**Re: Constantine Short Plat
8817 SE 44th Street
SUB20-004**

Please consider this as a written response to the City of Mercer Island first review comments dated February 2, 2021.

*From City of Mercer Island
SUB20-004 First Review Comments
2/2/2021*

DATE	11/04/2020
JOB NO.	
DWG NO.	
SHEET	5 OF 7

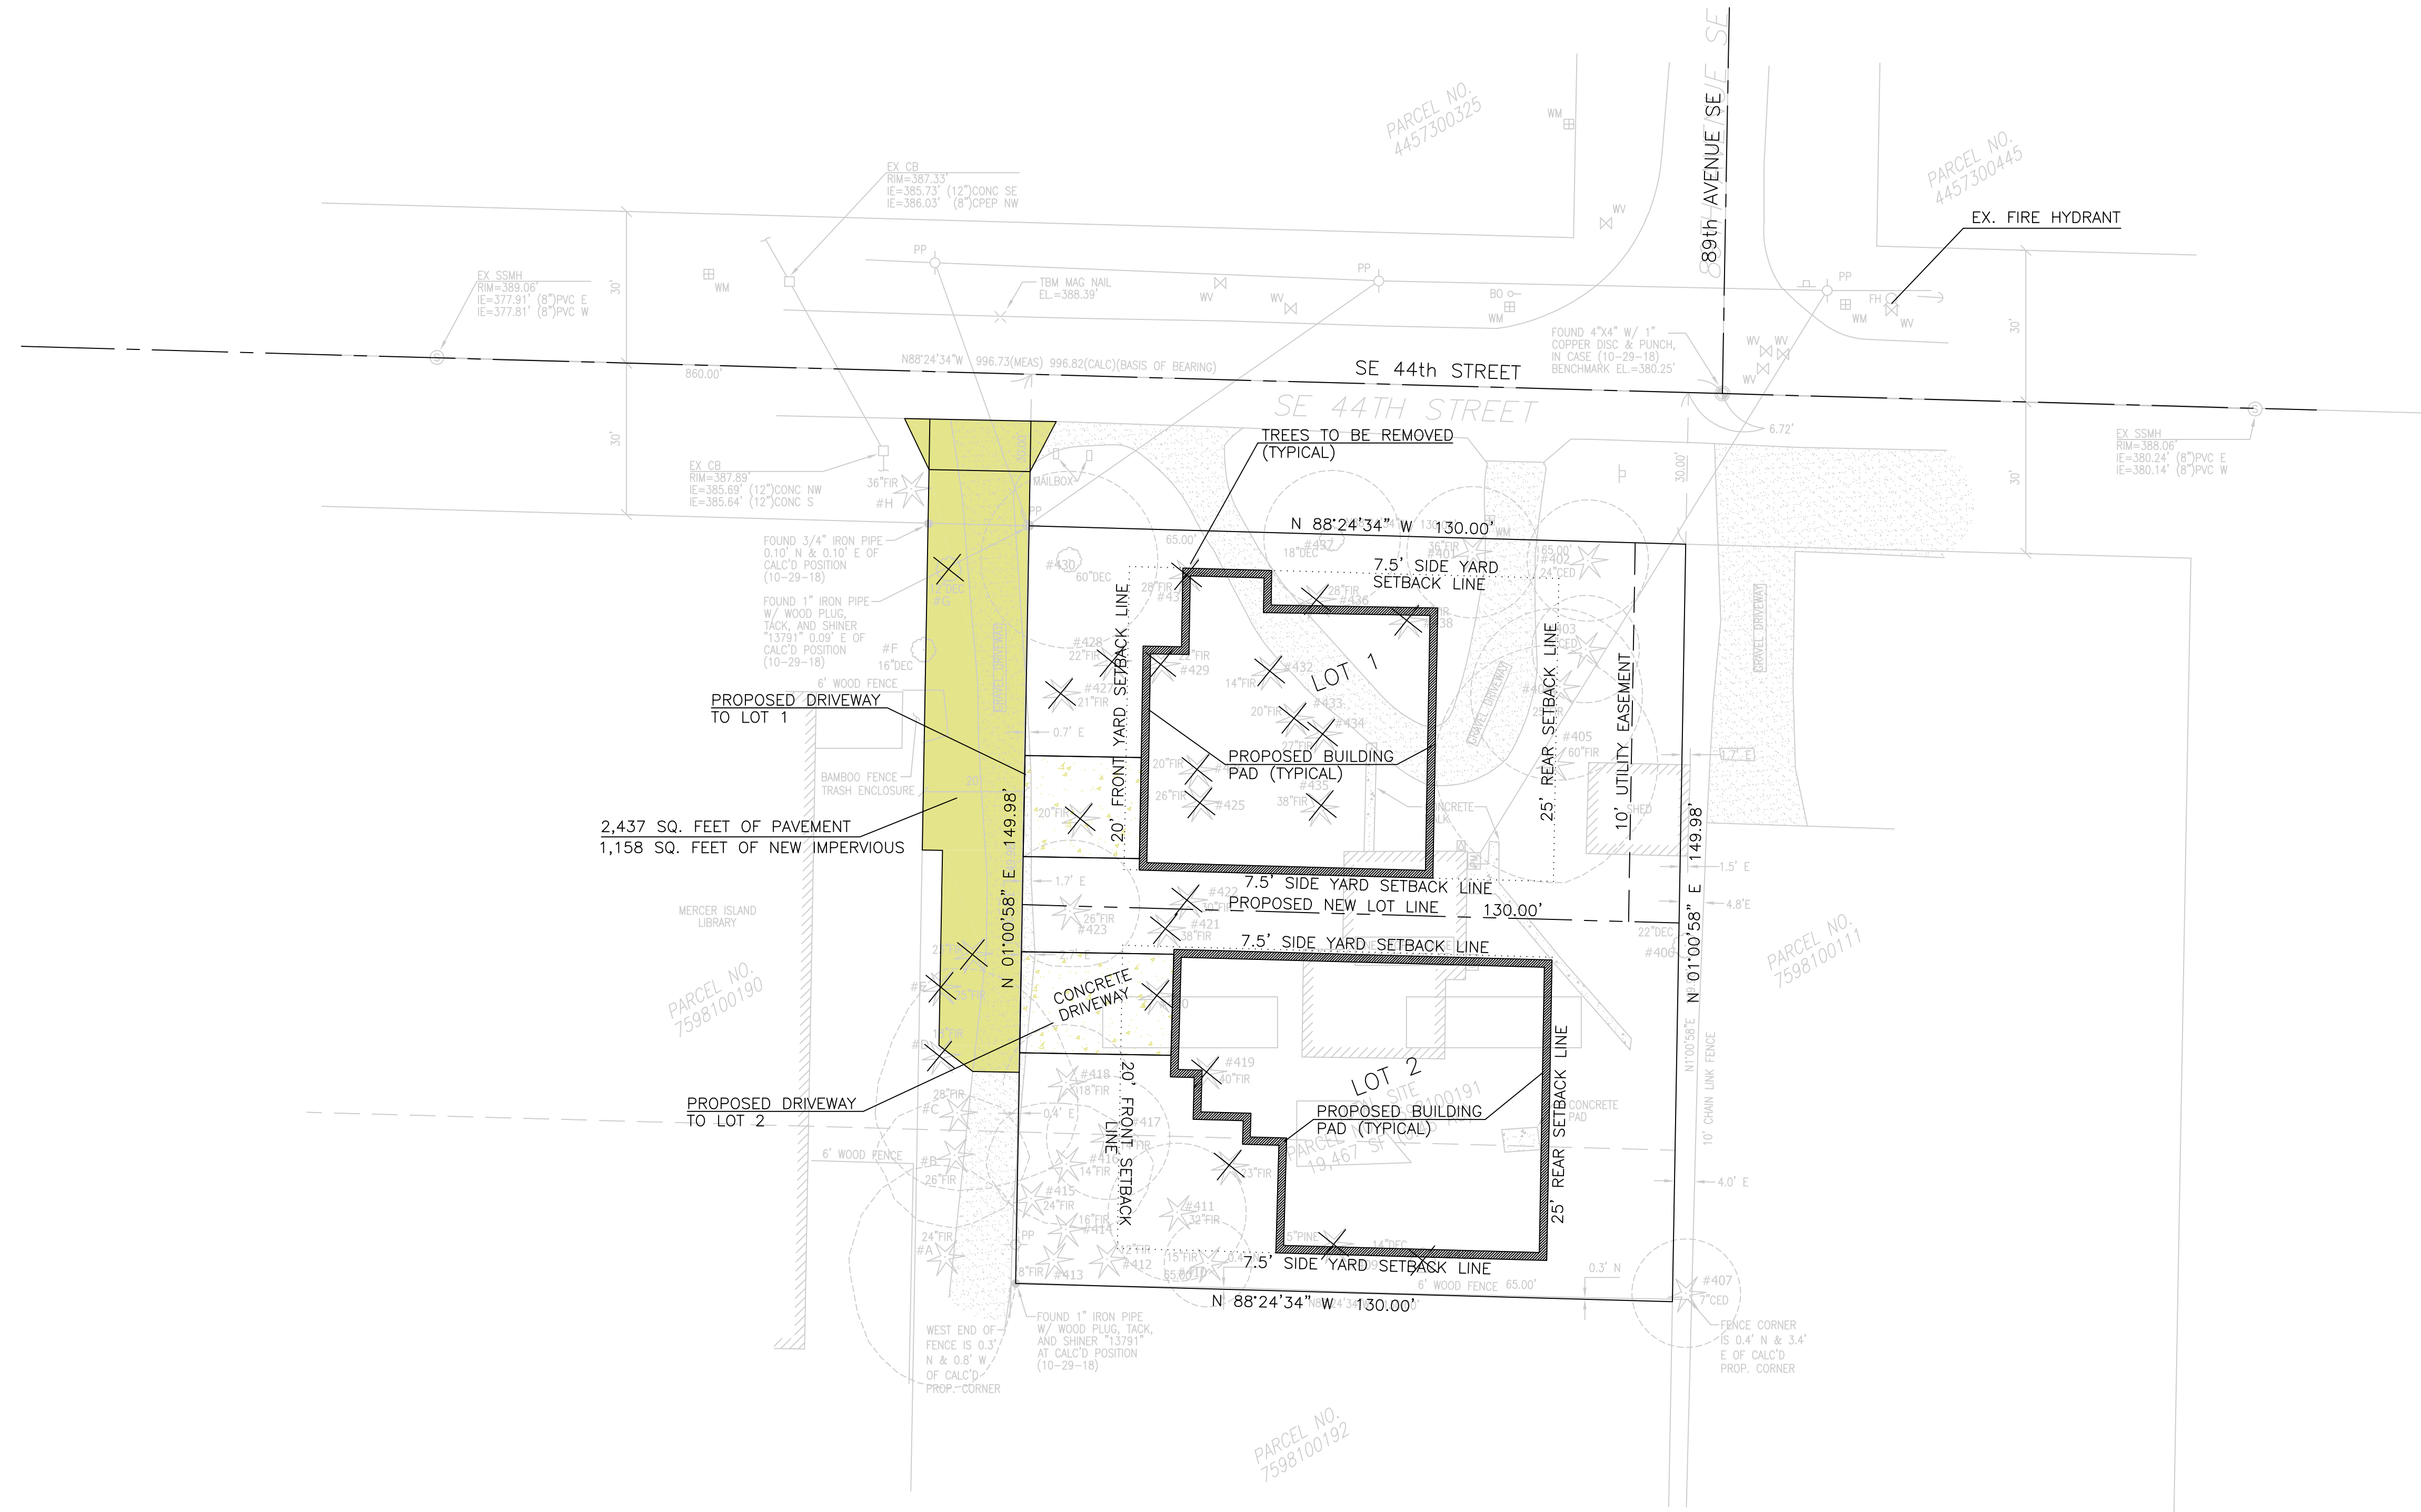
15. *Please note on all sheets that the existing house and shed will be demolished prior to Final Plat application. A note has been added to sheets 5,6 and 8 calling out the removal of the structures prior to final short plat application.*

17. *Please adjust the building pads of the proposed lots based on the comments from the City Arborist above. The building pads have been revised on Civil plan sheets 4,5 and 6.*

SHEET
7 OF 7

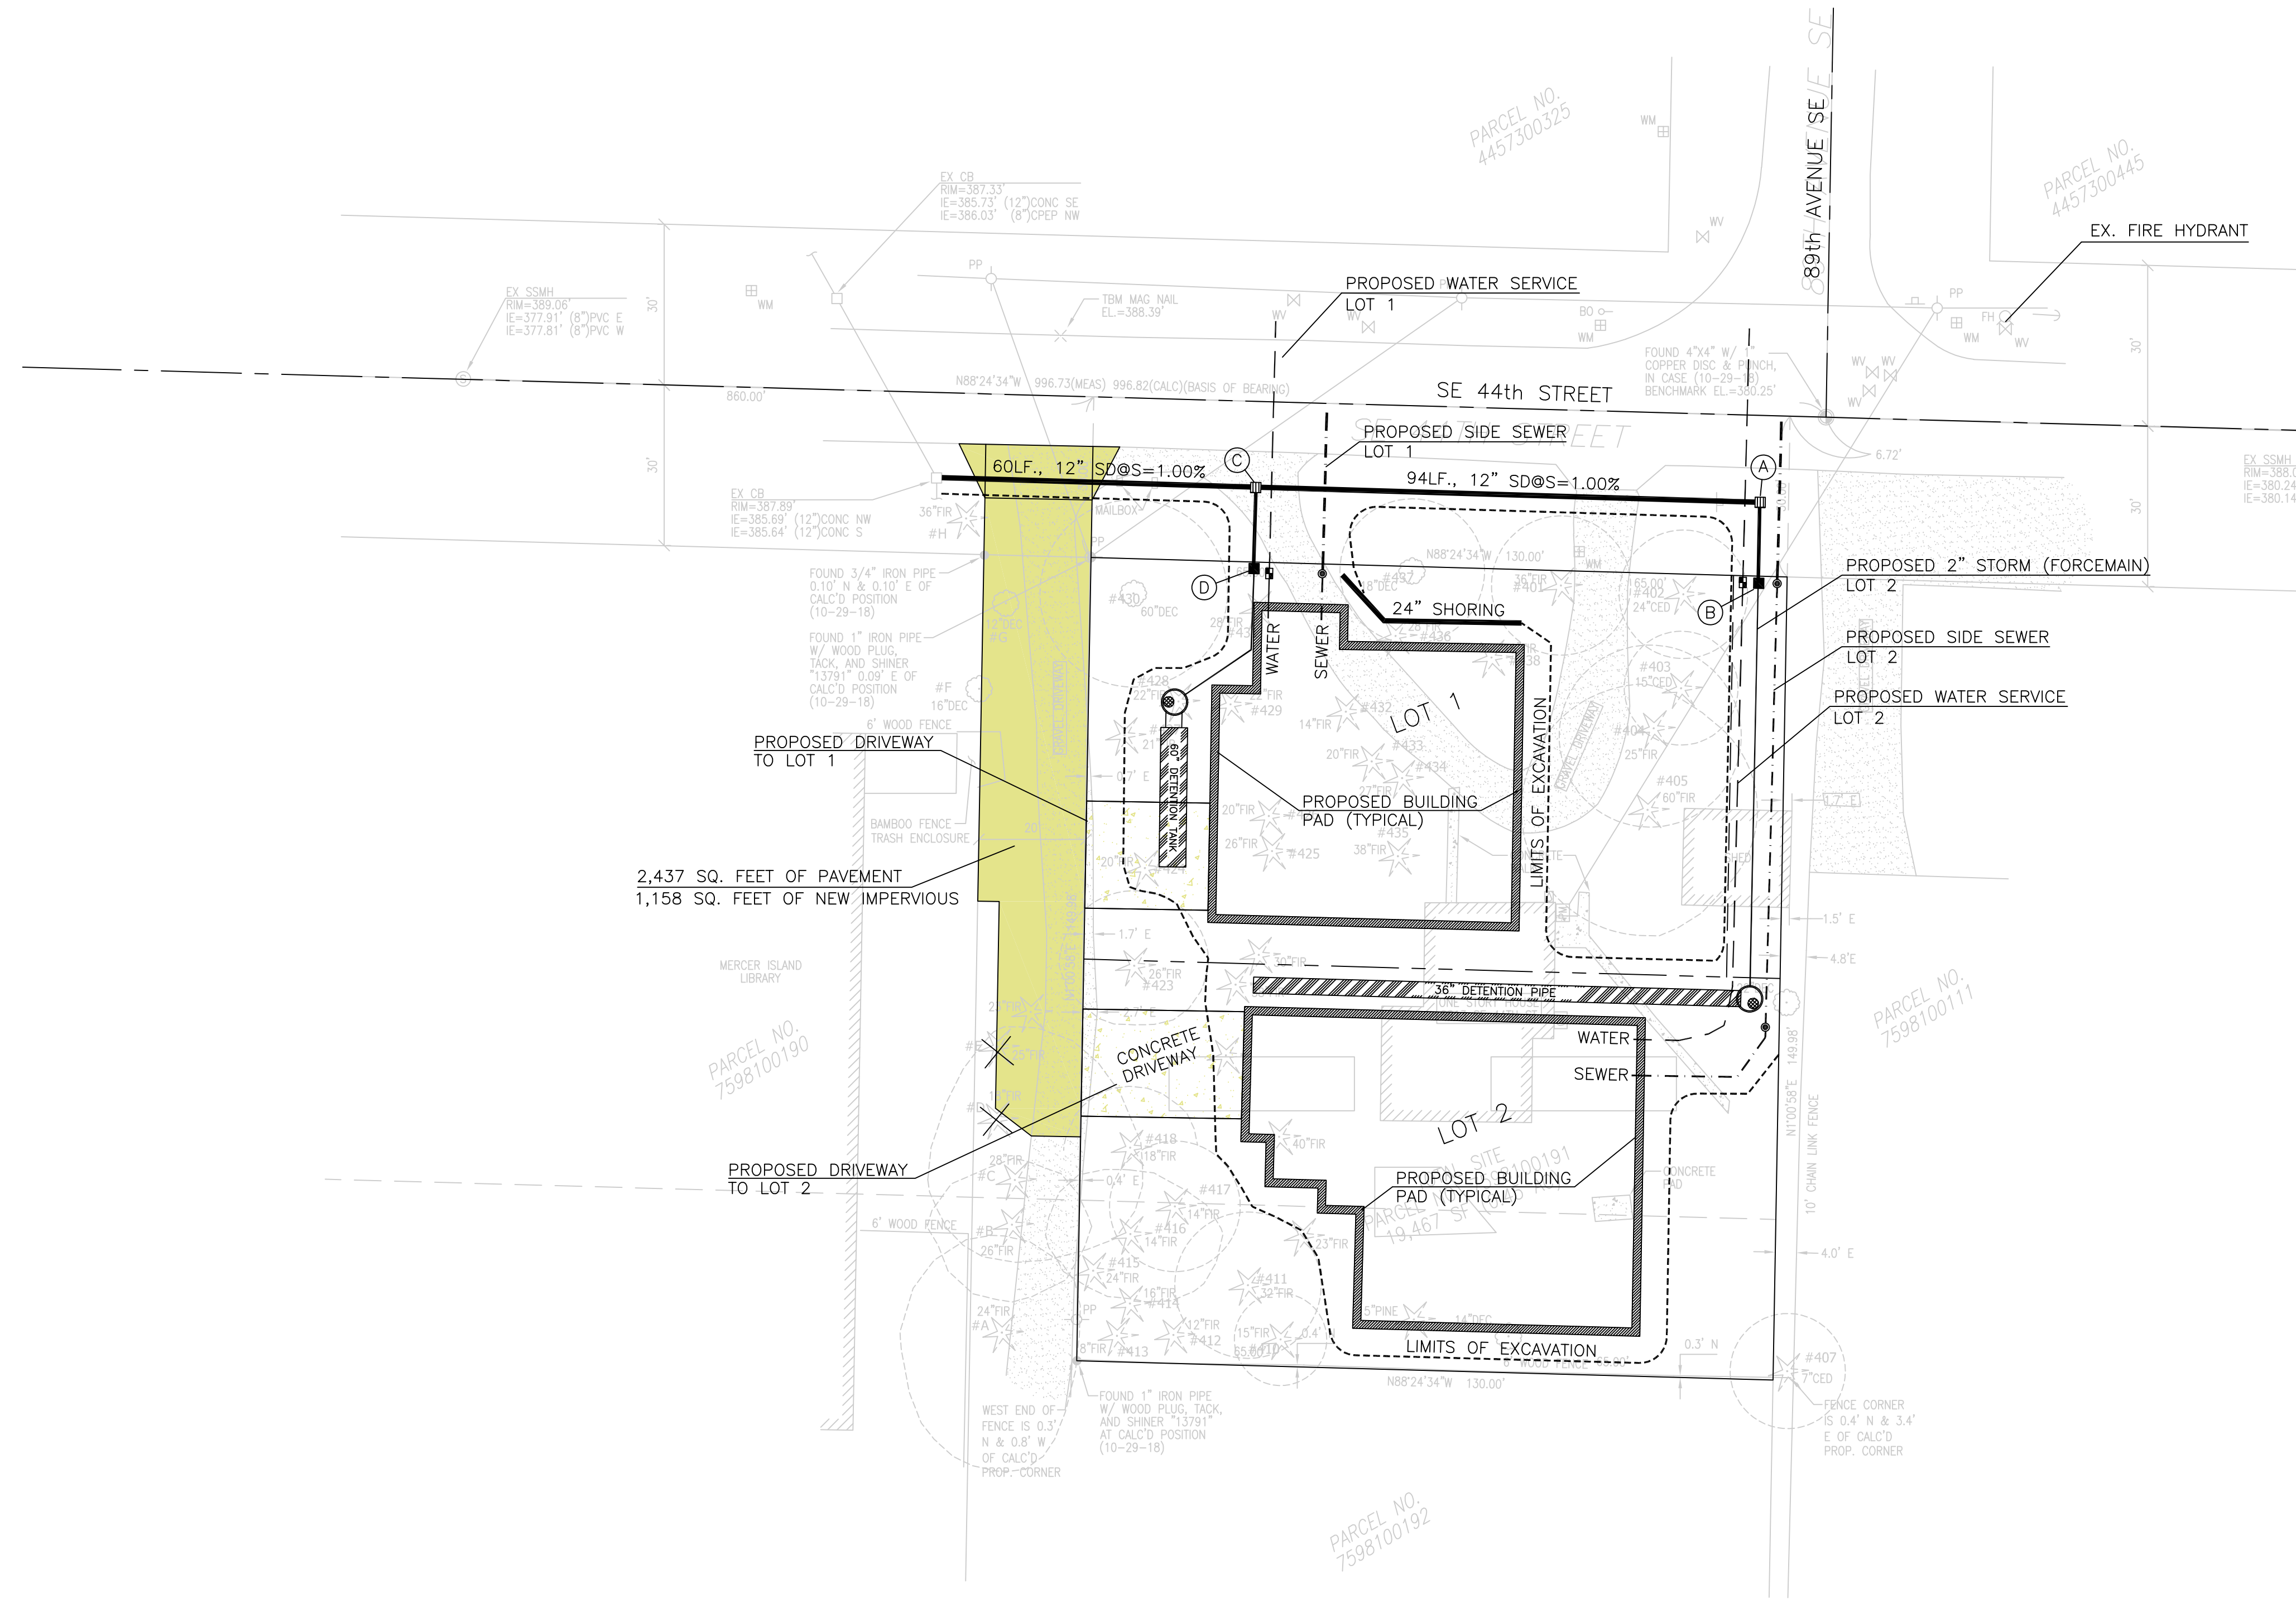
2. *Tree Plan shall contain all grading and utility information shown on sheet 7. Number tree 424. Mark all trees proposed for removal with an X. Show tree protection at trees driplines or at least Arborist given limits of allowable disturbance for all trees. Also call out chain link fence for all tree protection. See checklist below provided during pre-application meeting* The trees have been marked "X" for removal with the chain link fence call out shown on plan sheets #5 and #6. The arborist report and civil plans have been coordinated to reflect each other.
